**Application: SSI 7485**

I write regarding the proposed modification to M4-M5 Link, Mod 2 The Crescent overpass and changes to pedestrian infrastructure in North Annandale, Rozelle and Rozelle Bay Foreshore area.

Figure 4-2 Pedestrian and cyclist bridge infrastructure options

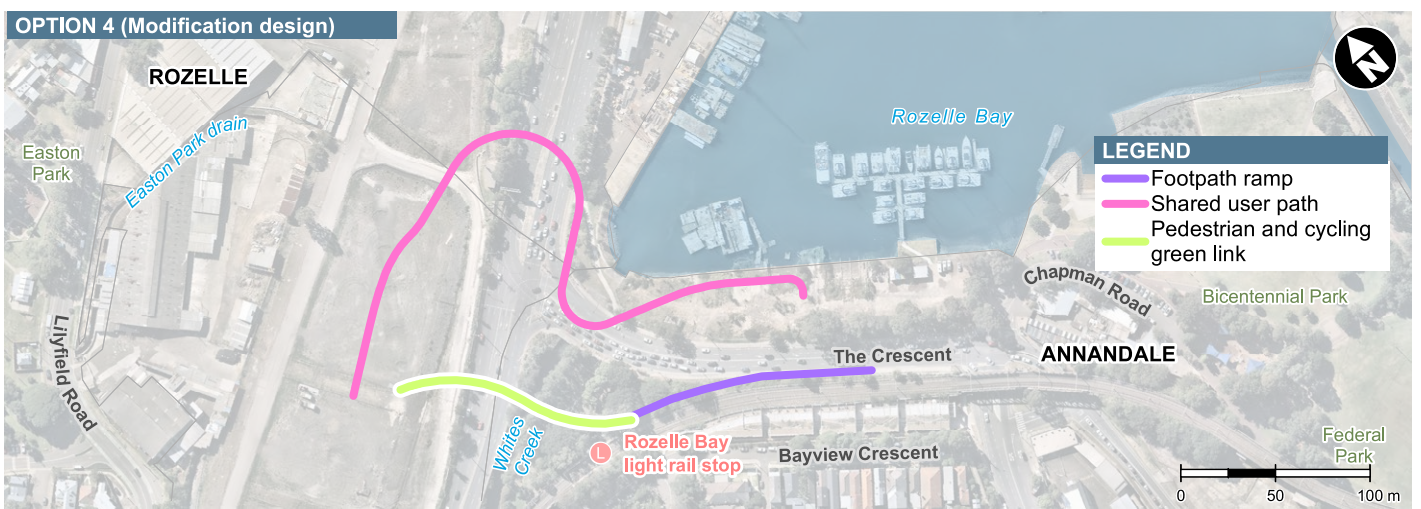
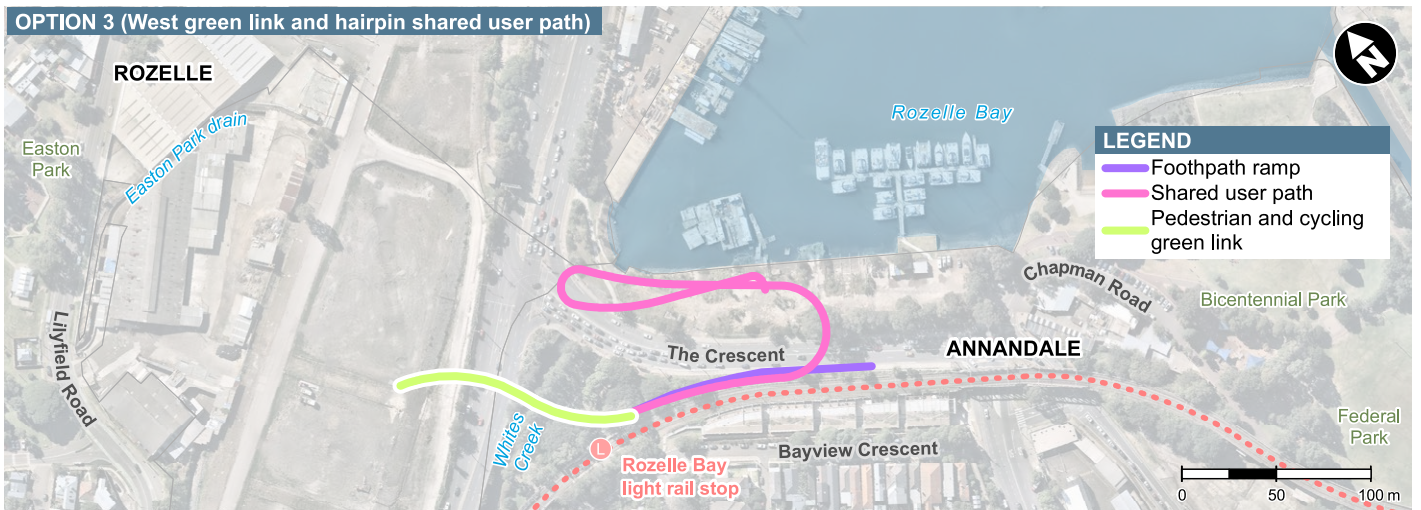
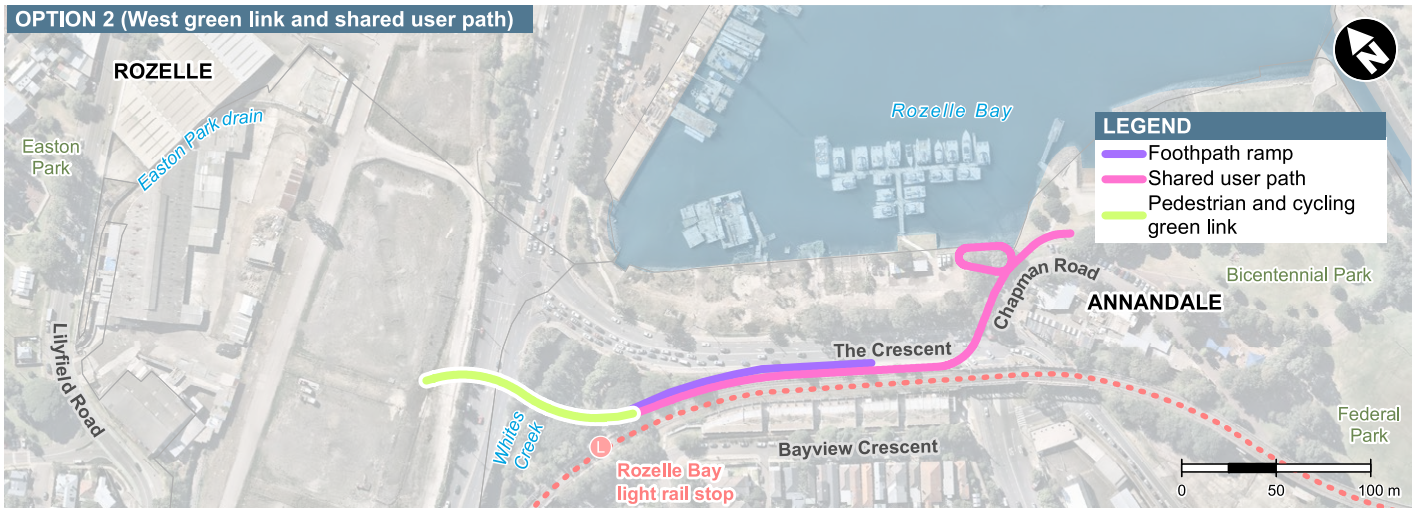
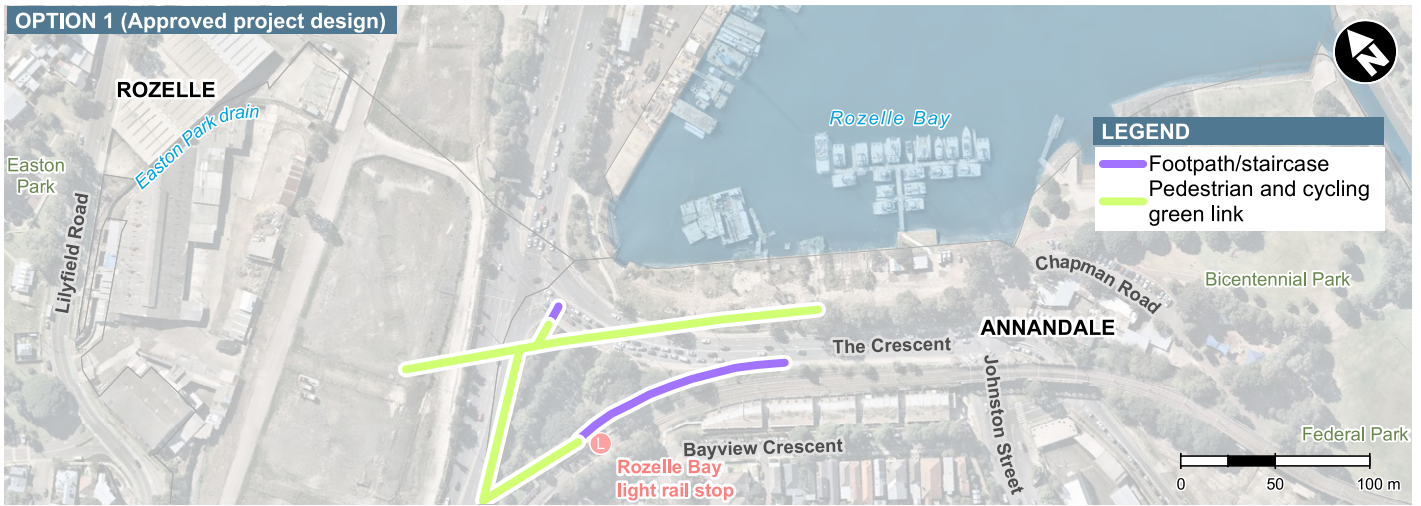
I request RMS work with the community to explore alternate design options to the proposed new car overpass design and the changed pedestrian and cyclist links. I am seeking the reinstatement of the safe, direct access from the approved EIS GreenLink to create a continuous green open space connection from the Rozelle Rail yards and Annandale to the foreshore. The GreenLink was more than just a walk way - it put people central to the design, maximising safety, and providing much needed accessible open space for the community now and into the future Bays Precinct design.

- The significantly reduced safety and increased risk for pedestrians and cyclists with removed access over The Crescent to Bicentennial Park and the increased traffic along Johnson Street.
- Being required to cross five sets of pedestrian lights at The Crescent as my option to reach the foreshore from Annandale or from Rozelle Bay light rail stop.
- Removal of direct active links to the foreshore, cutting the community off from the area and the proposed revitalisation of the entire Bays Precinct, including linking the Light Rail and Bus stops to a Ferry wharf and Metro station.
- Urban and landscape design that is being built before a finalised Masterplan for the area.
- Traffic changes that limit movements around the suburb and create further congestion in the local streets of Annandale, Forest Lodge, Glebe, Lilyfield and Rozelle with no planning to deal with these.

I regularly access Bicentennial Park via the Crescent. At the moment it is an unsatisfactory one traffic light. With this mod it would be five lights. My children get themselves to Jubilee Oval at the moment. The Mod2 would make that UNSAFE.

- Reinstate the GreenLink connecting communities and green open space from Rozelle to Bicentennial Park
- Relocate and design pedestrian and cyclist connections that are continuous, safe and direct.
- Design the modification infrastructure and active links in response to the character of the suburbs, the location of the foreshore and it's potential future development.
- Provide pedestrian and cyclist paths that maximise people safety and do not force them onto busier streets, unsafe concrete plazas and caged walkways.
- Integrate active and direct connections to all active transport – including the future Metro West and Foreshore Ferry Wharf
